Consultation Response from: KC Environmental Health (Pollution & Noise Control)
2024/93155 - Former Conservative Club, Stocks Lane, Batley, WF17 8PA
Change of use from conservative club to retail, cafe (hot food), external alterations to form covered seating area and accessible entrance to the main entrance, erection of extension to form two retail units and plant room (within a Conservation Area)
**Responding Date:
21 January 2025**
**Responding Officer:
Mohammed Nasim**
**Responding Ref:
WK202500497**
Comments
Noise

First Floor - Proposed

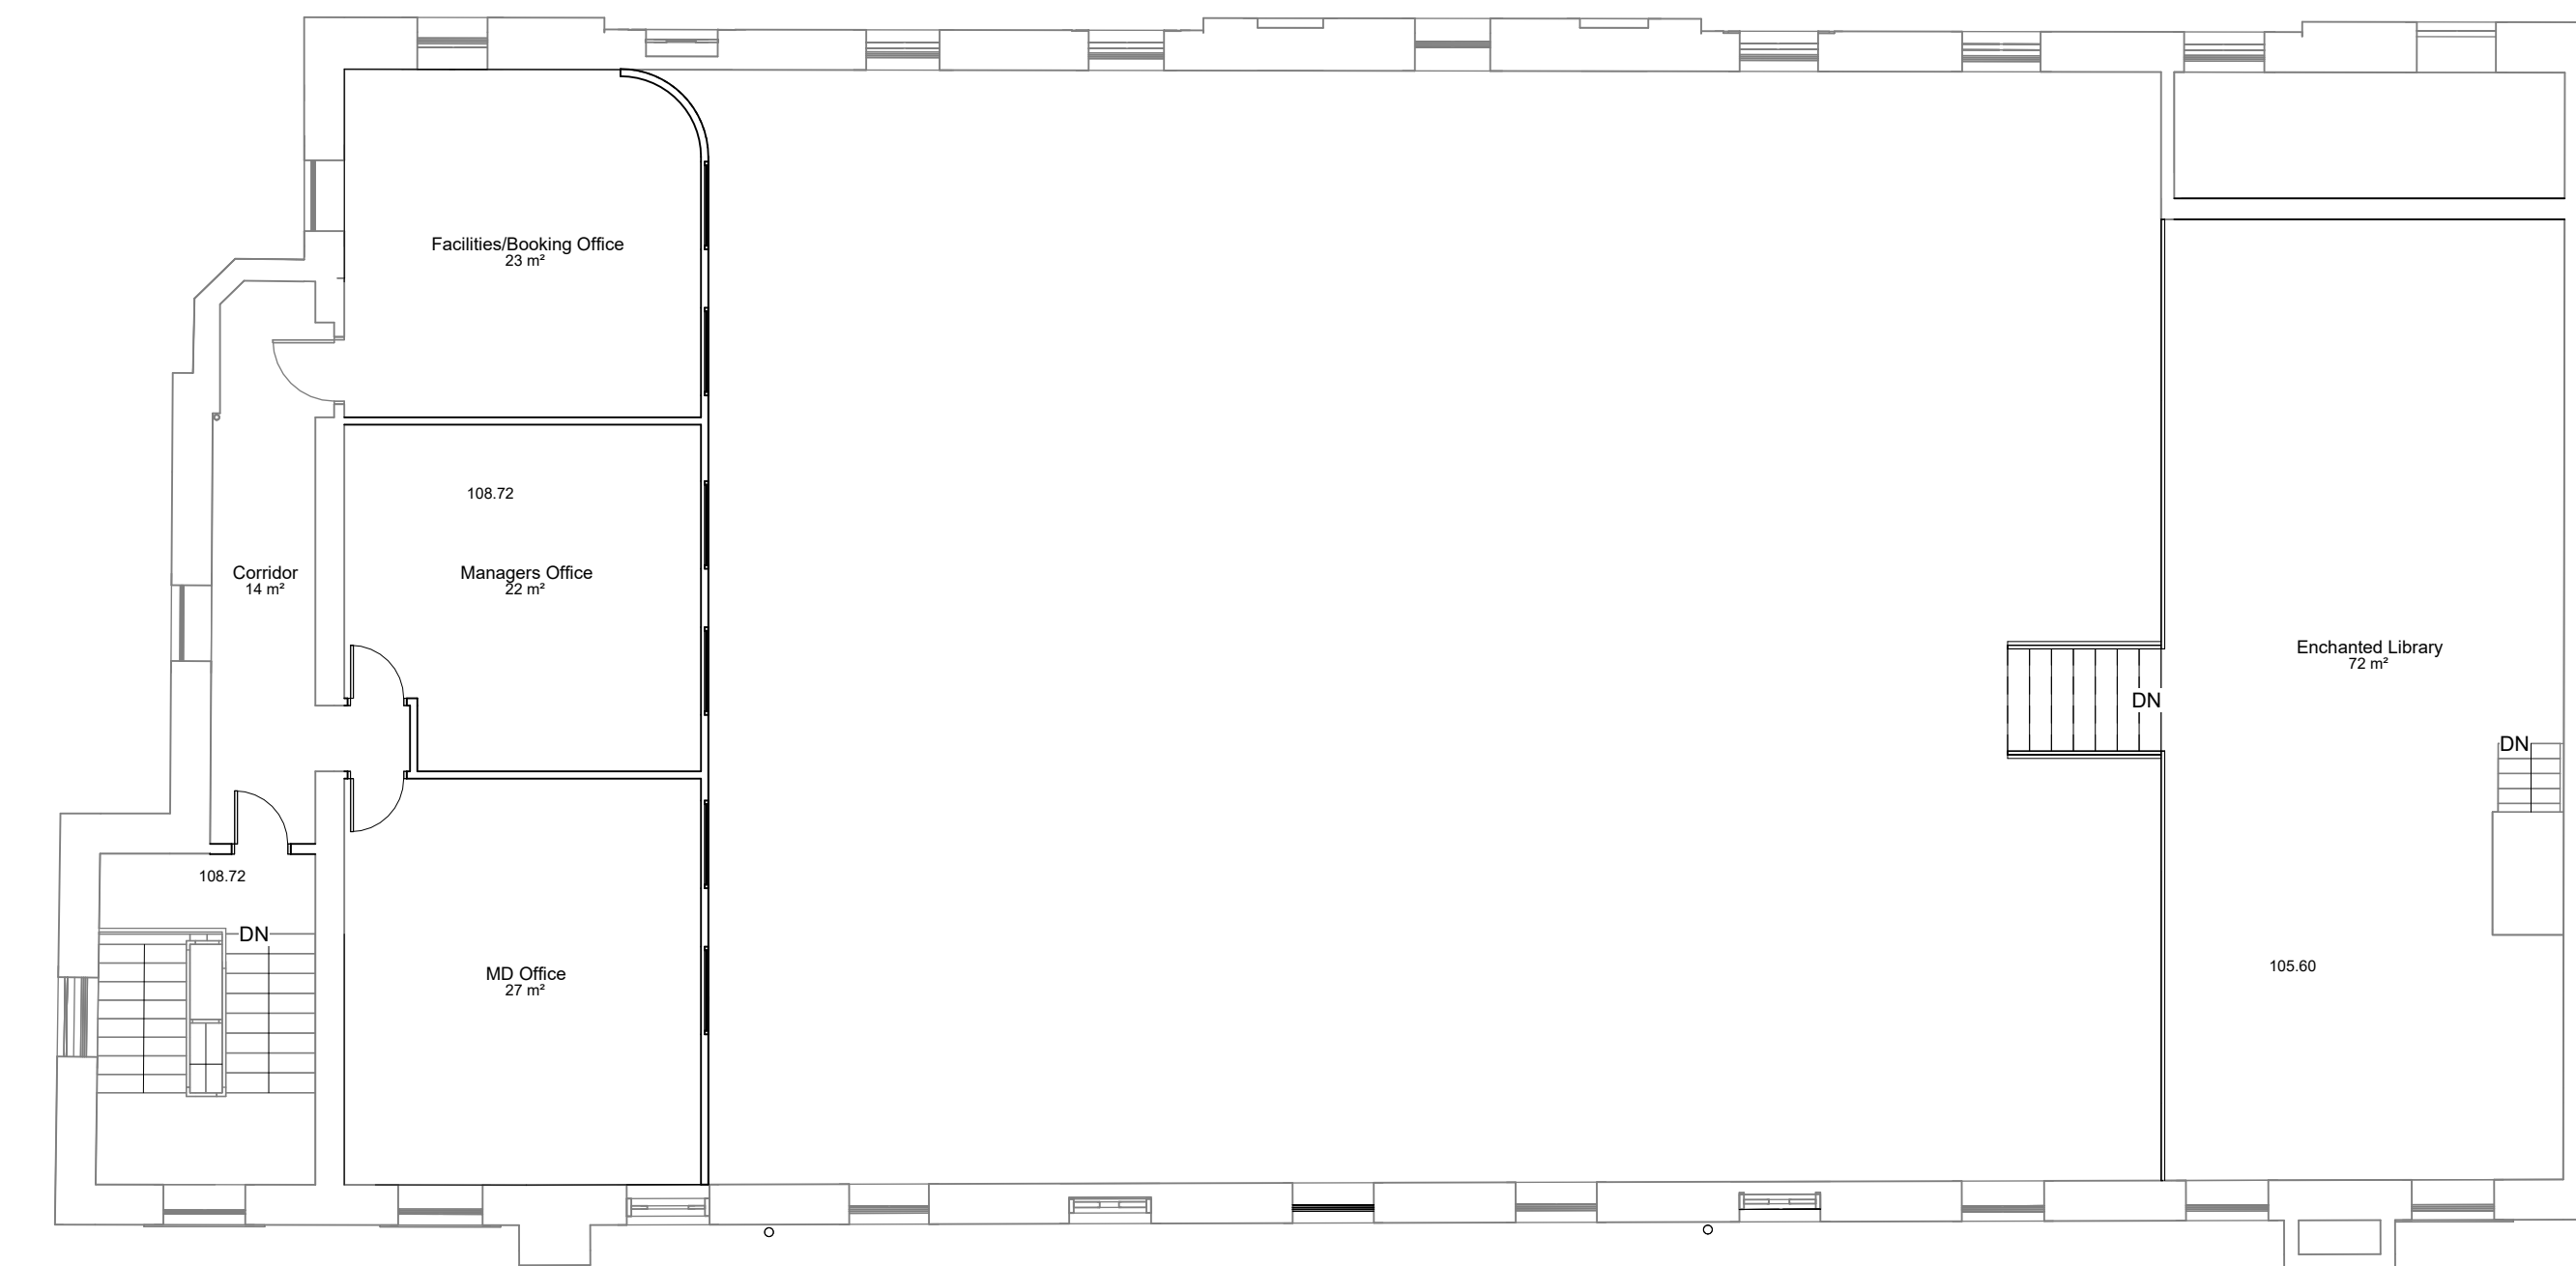
There are some residential properties in the immediate area and consideration must be given to minimising any noise from the proposed use. The proposed covered outdoor seating area to the rear of the building which will be used by the café to serve hot food and drinks, has the potential to generate noise which may lead to a loss of amenity. A condition is recommended for the submission of a Noise Management Plan which should address the use of this area.

There is nothing within the submitted information to show the plant room and this will need to be clarified. Similarly, we seek clarification on whether there is to be any fixed mechanical plant serving the café i.e. kitchen extract, refrigeration/air conditioning etc. as there may be noise emissions that may require mitigation. A Noise Impact Assessment may be required to determine this.
